Ecological comments

Planning Application No: **3/2014/0438**

Proposals: **Development of 106 residential units, including affordable housing, new vehicular and pedestrian accesses, landscaping, public open space and ecological enhancement measures**

Location: **Land East of Chipping Lane**

Drawing:
Boundary Treatment Plan

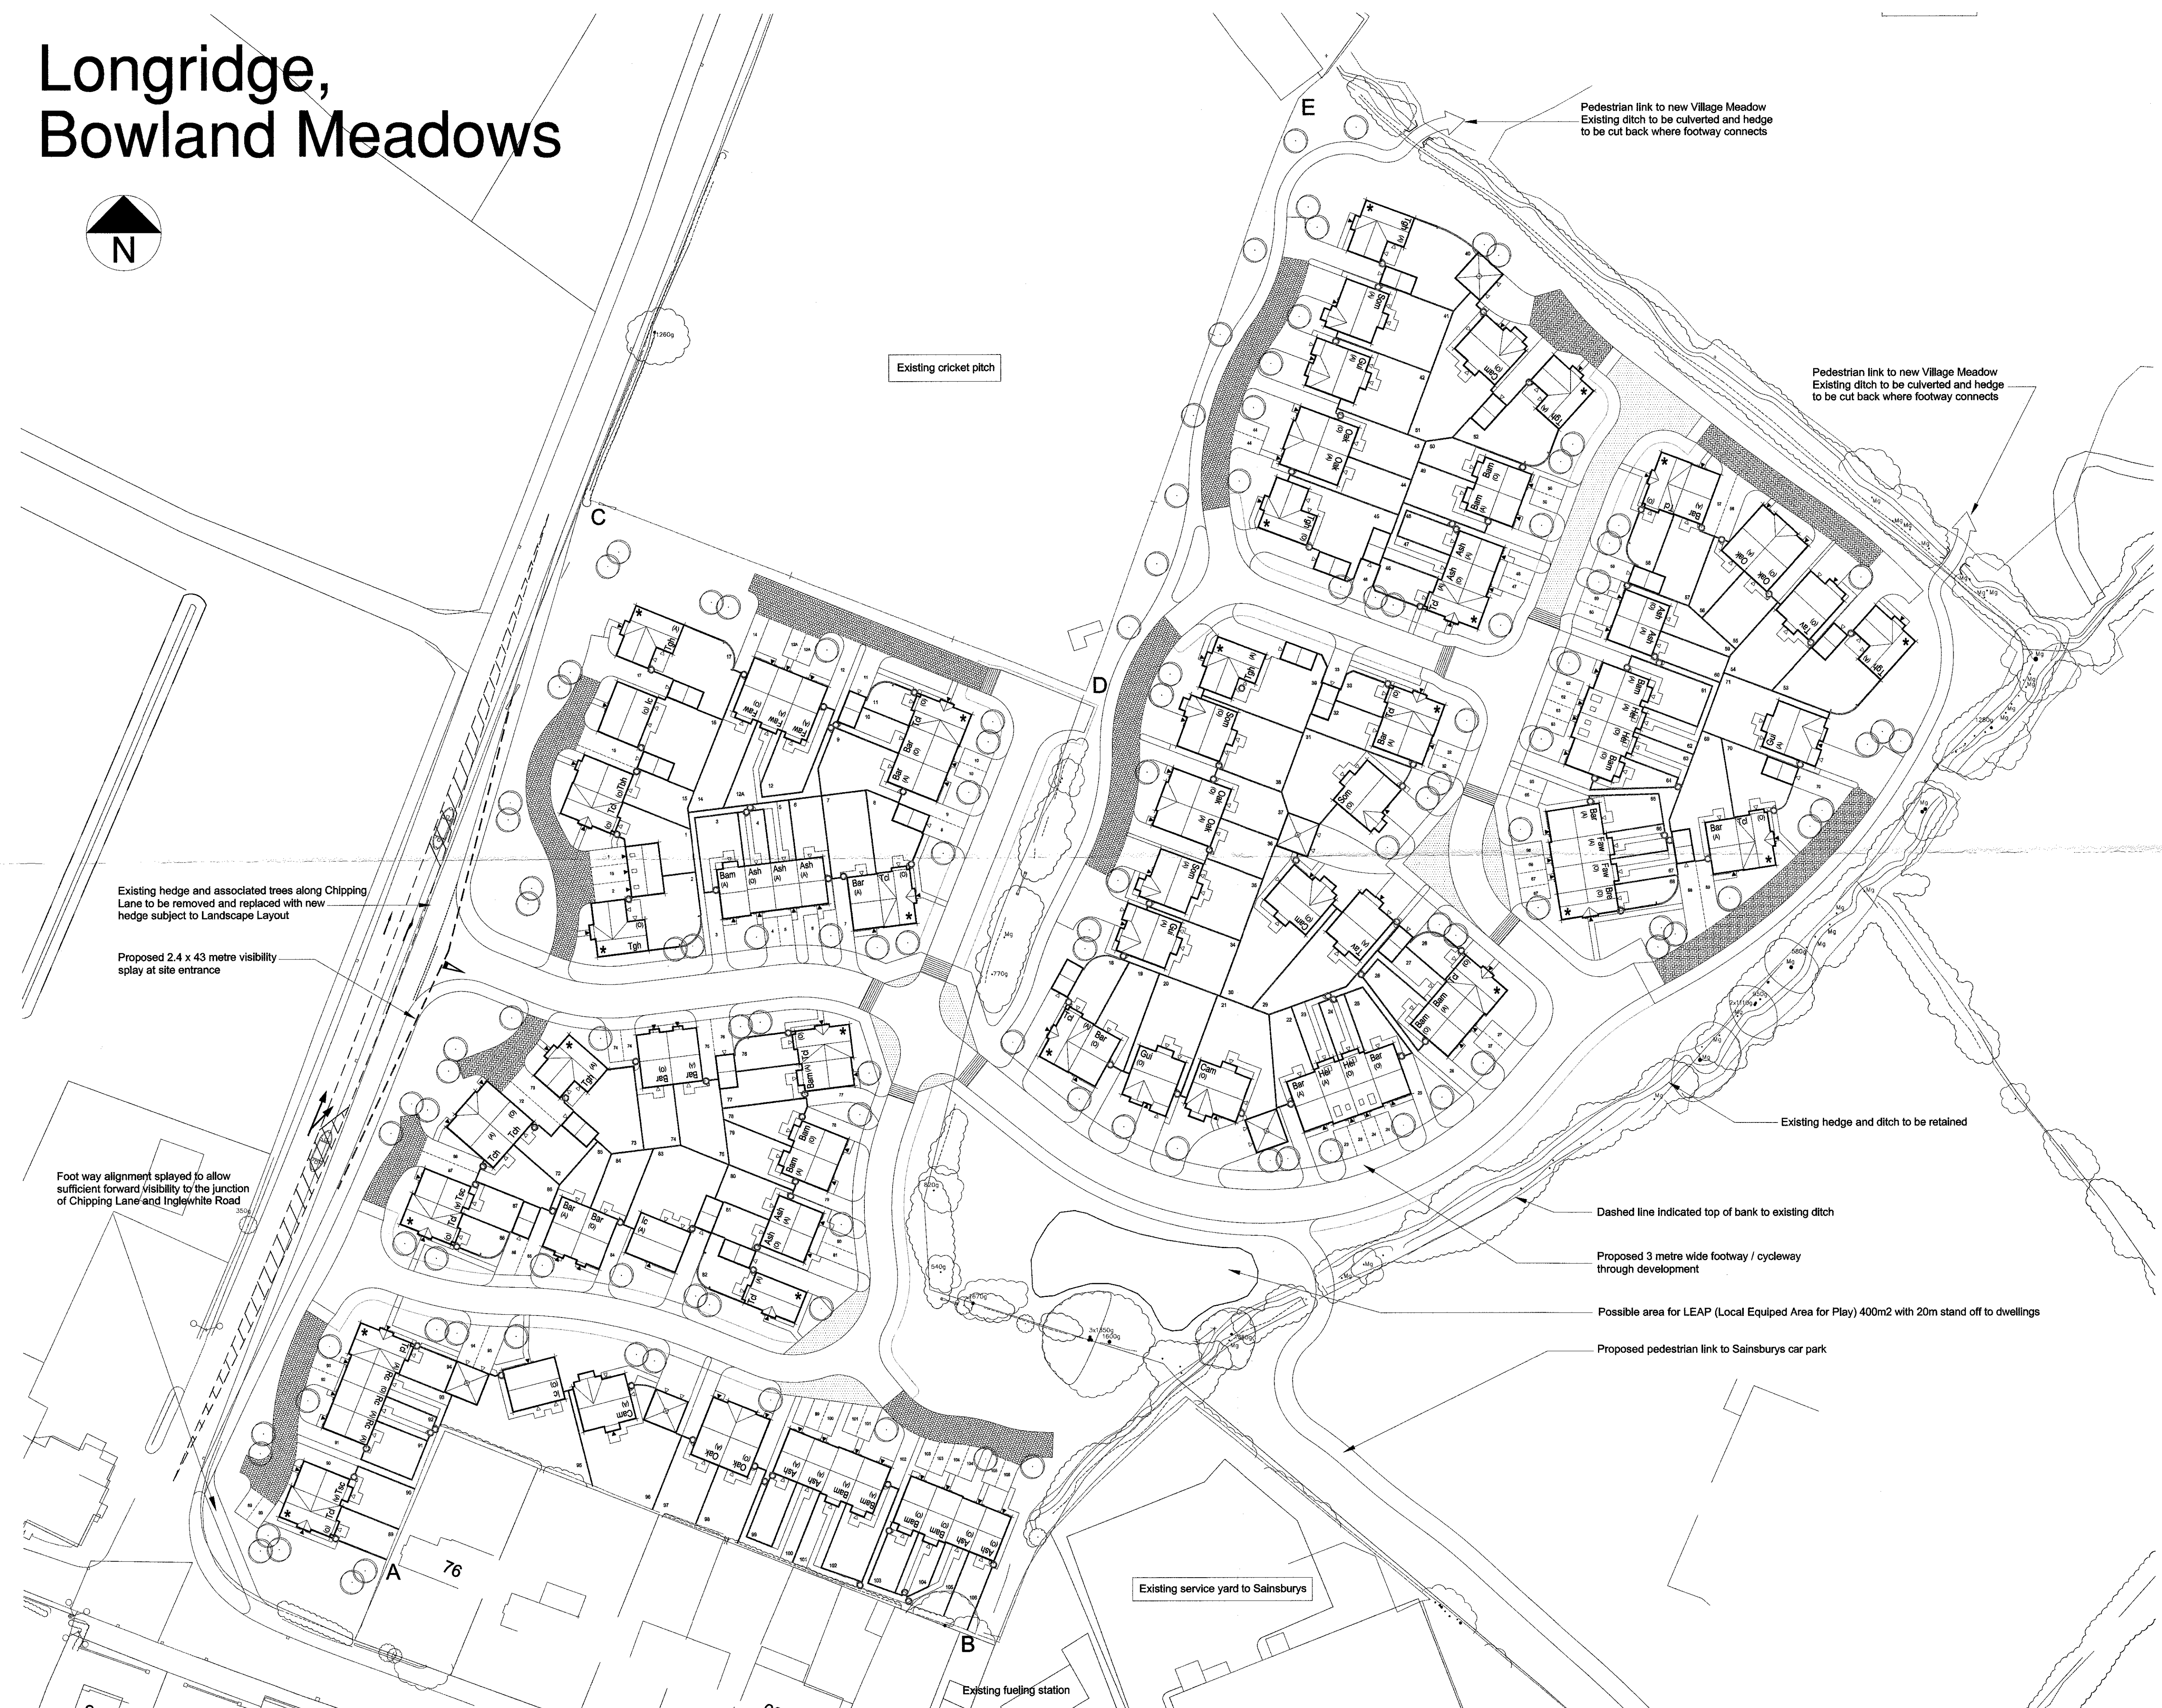
- 5 mature trees are proposed for removal (Site Layout plan). Based on the submitted information it is not clear to me whether the presence of bat roosts in these trees can be reasonably ruled out. Further information should be submitted to address the following matters:

- The 3 trees along the site frontage (Chipping Lane) (T18, T19, T20, Ecological Assessment Report) to be removed are categorised as having no potential to support roosting bats (appendix 4, Ecological Assessment Report), however, the descriptions provided highlight the possible presence bat roosting features:

- I recommend that the Environment Agency and/or LCC Flood Risk Management team are consulted reading the proposals to culvert ditches and dispose of surface water into existing watercourses.
